REQUEST	Current Zoning: BP(CD), business park, conditional Proposed Zoning: MUDD-O, mixed use development district, optional, five year vested rights
LOCATION	Approximately 60.30 acres located on the south side of West Arrowood Road between Interstate 485 and Whitehall Executive Center Drive.
CENTER, CORRIDOR OR WEDGE	Center
SUMMARY OF PETITION	<p>This petition proposes the development of 1,800,000 square feet of office uses, 40,000 square feet of stand-alone commercial, and 400 multi-family units at a density of 57 units to the acre.</p> <p>The petition proposes options to allow heights greater than 120 feet, drive-in windows, parking between the buildings and setback along Arrowood Road and signage flexibility.</p> <p>The petition also proposes a five year vested rights.</p>
STAFF RECOMMENDATION	Staff recommends approval of this petition upon resolution of outstanding issues. This petition is inconsistent with the <i>Southwest District Plan</i> , with respect to the amount of office square footage and the <i>General Development Policies</i> , with respect to the proposed residential density. However, staff supports this request given the site is accessed from a major thoroughfare

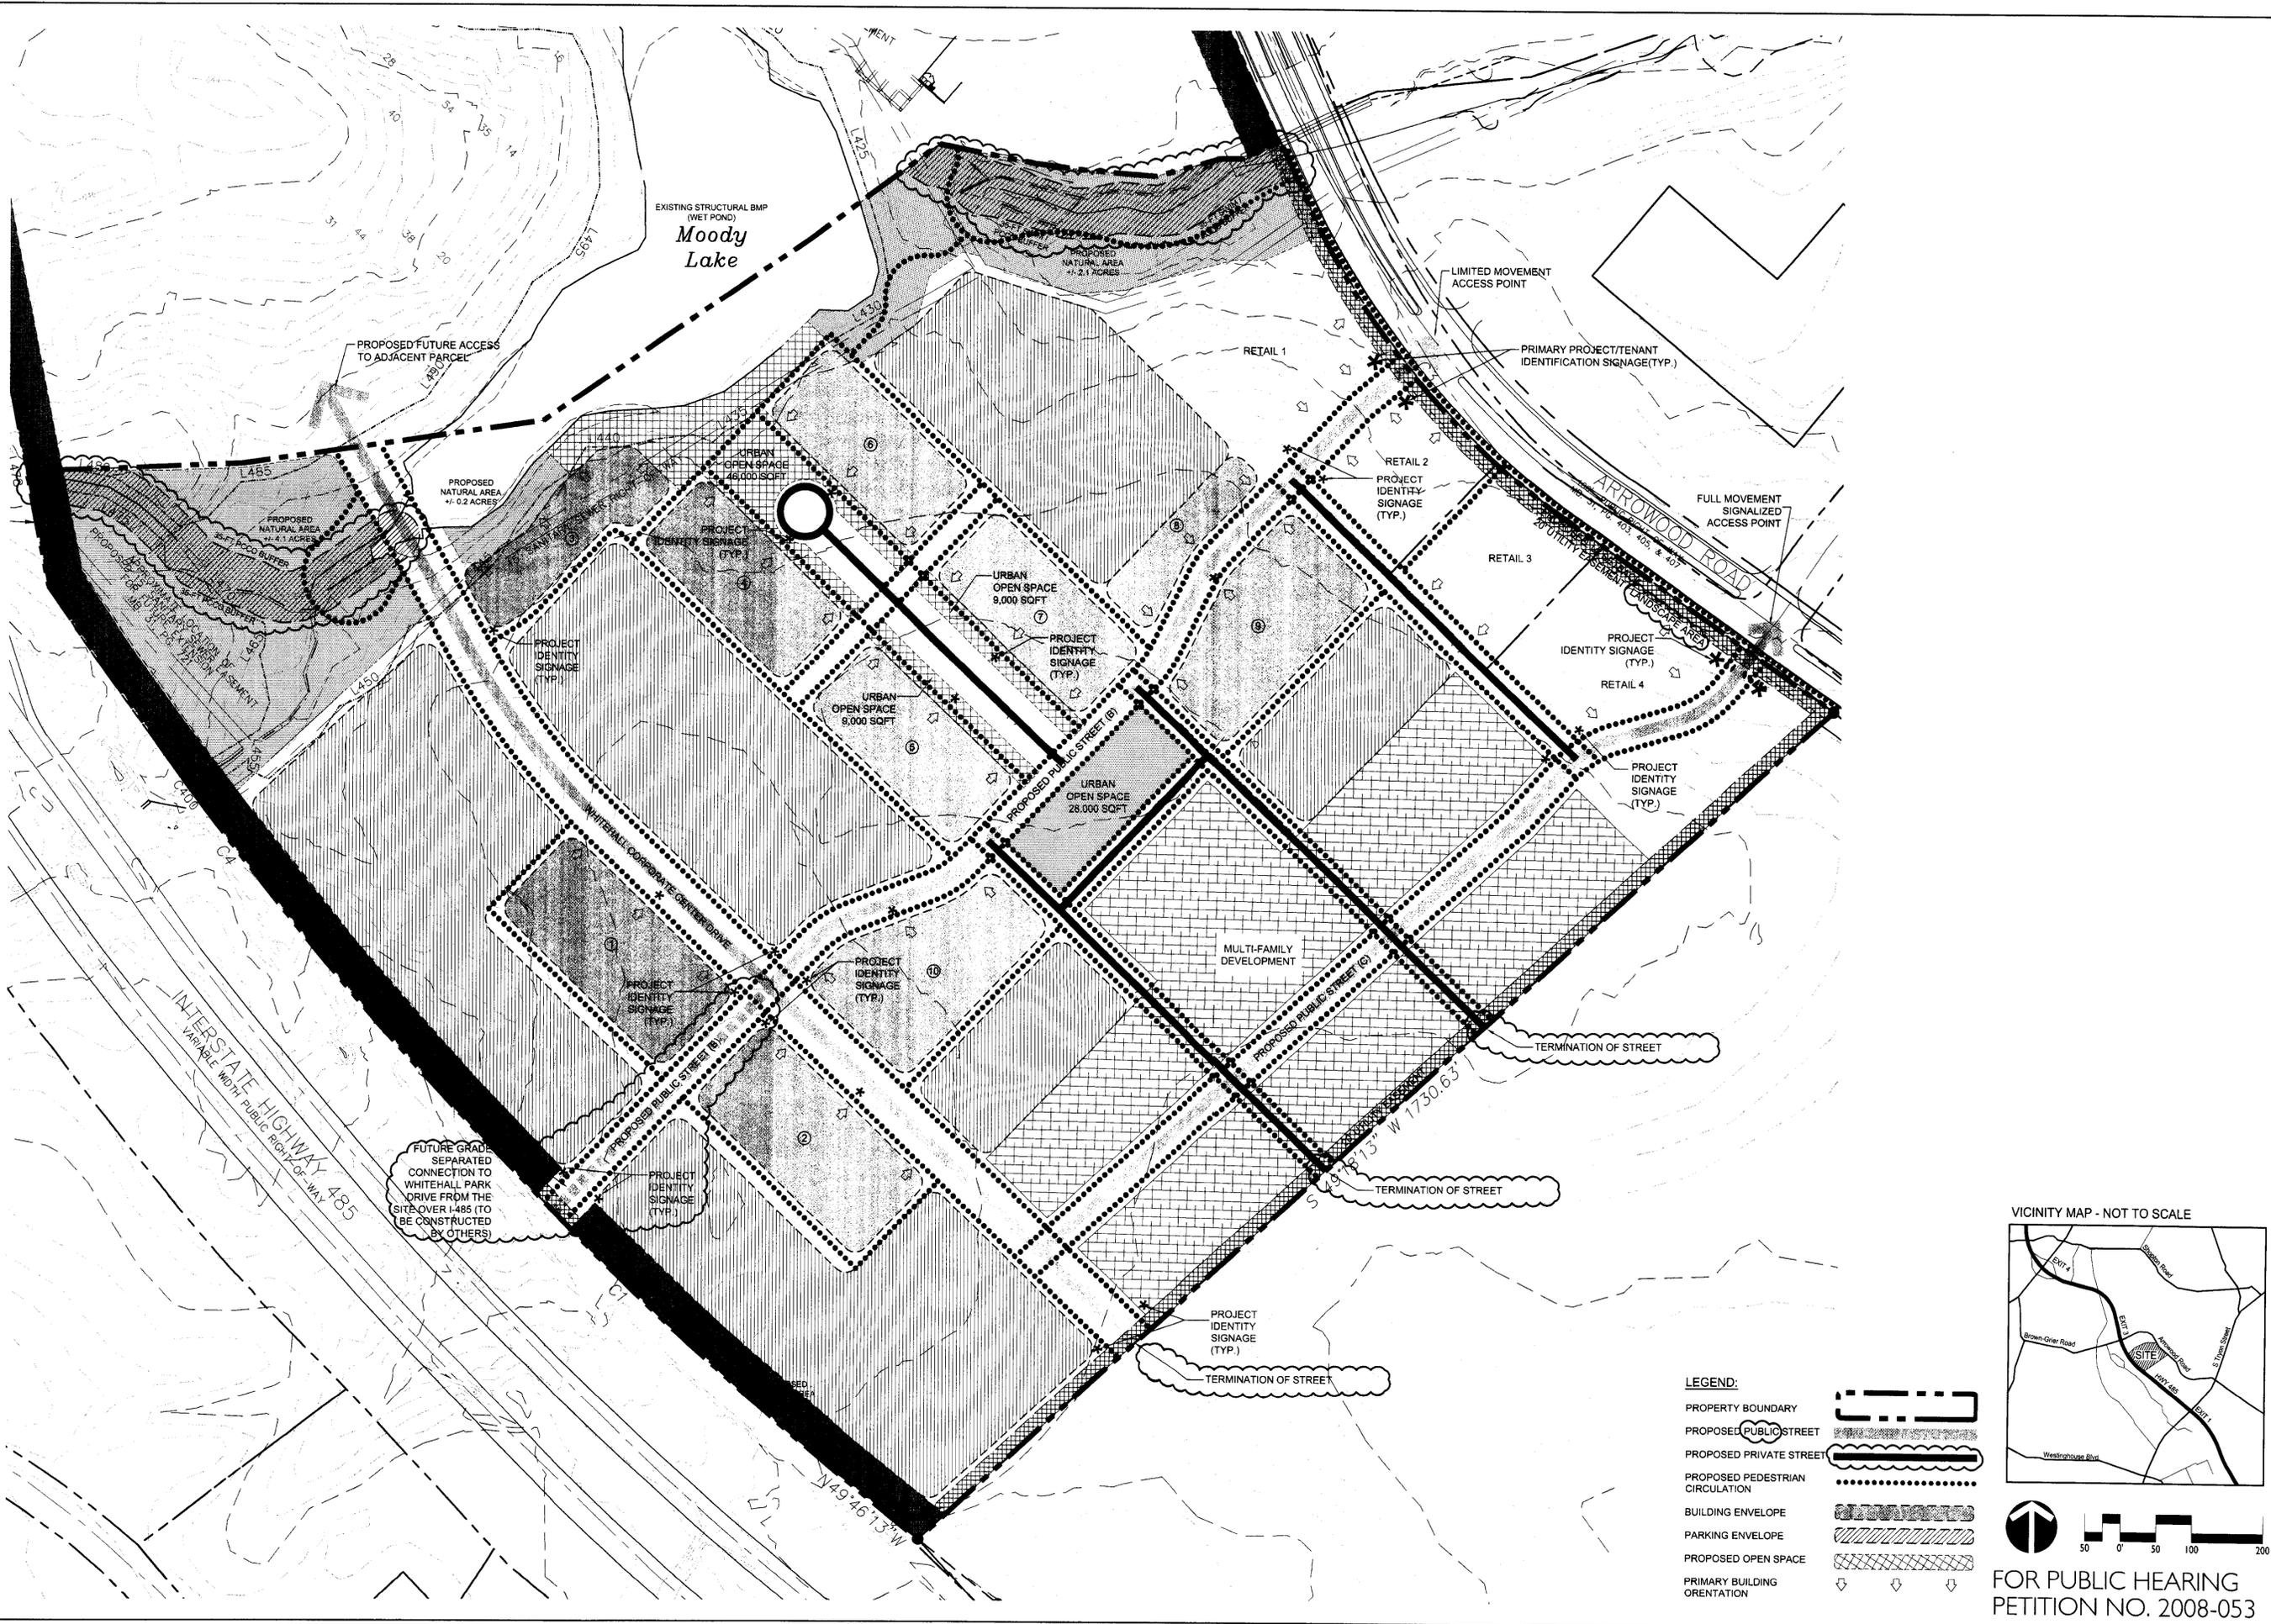
1. Note the height will not exceed 180 feet or 12 stories.
 2. Label the two terminations for the two private streets to the multi-family zoning to the south as possible future connections with cross access easements provided.
 3. Clarify that only two drive-in windows will be allowed in the locations shown on TDS.2.0.
 4. Clarify that parking and maneuvering between the building and setbacks will only be allowed on the one building shown on TDS.2.0.
 5. Note building orientations on outparcels will be as depicted on TDS.2.0.
 6. Address Parks and Recreation and CDOT comments.
-

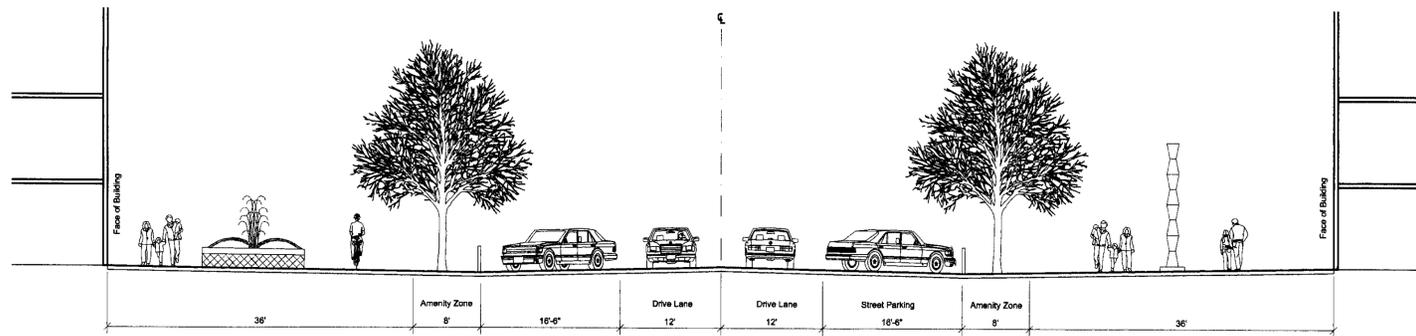
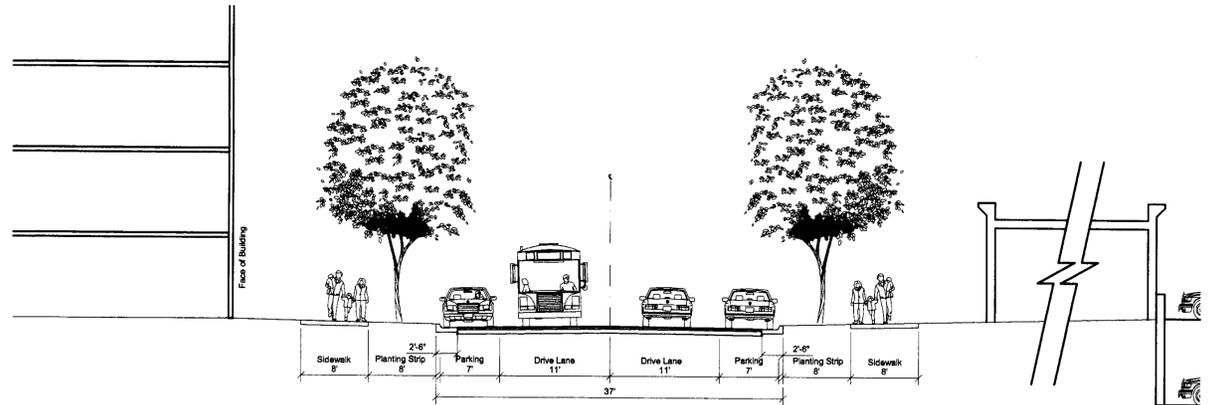
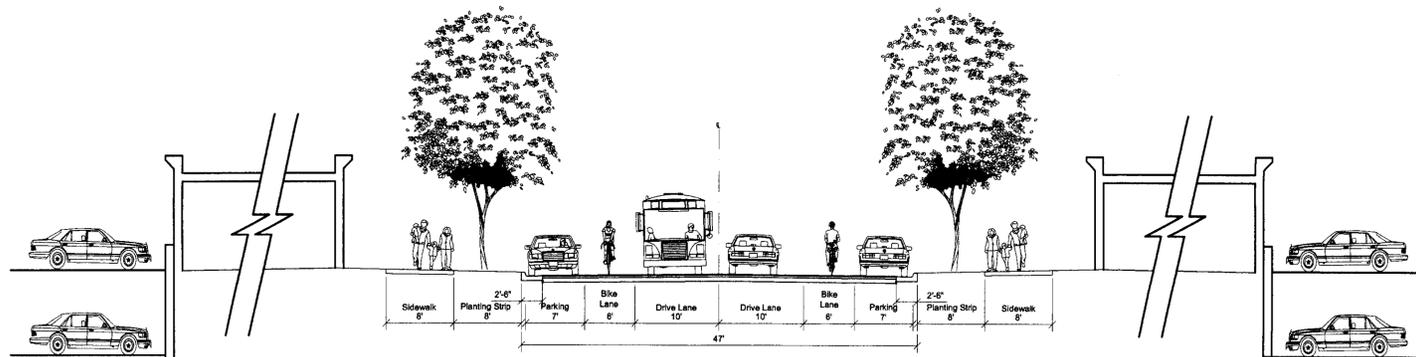
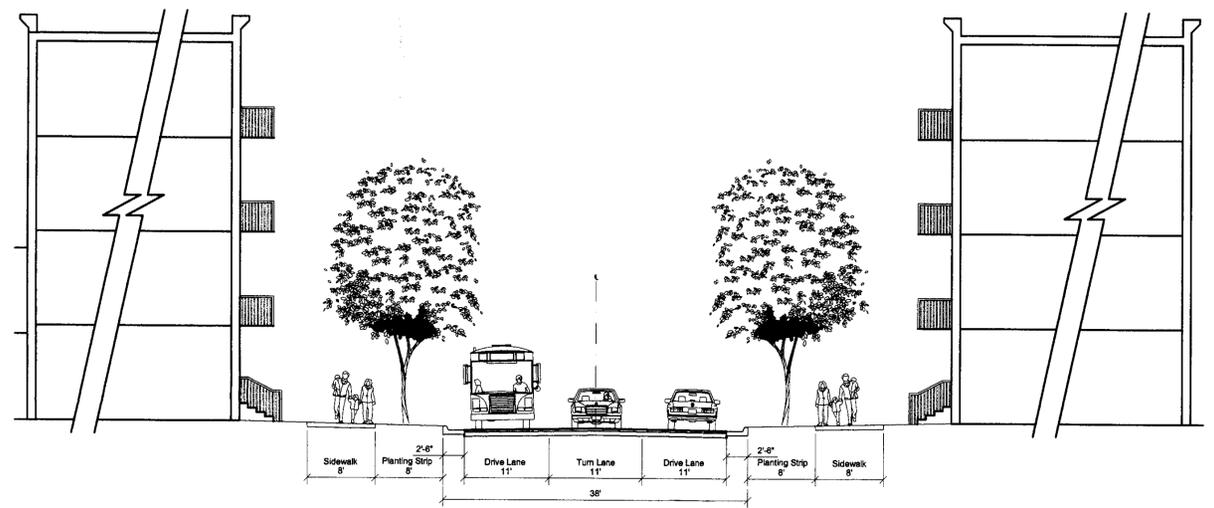
Parks and Recreation: Requests the sidewalk width along Arrowood Road be increased to eight feet to serve as a future greenway overland connector.
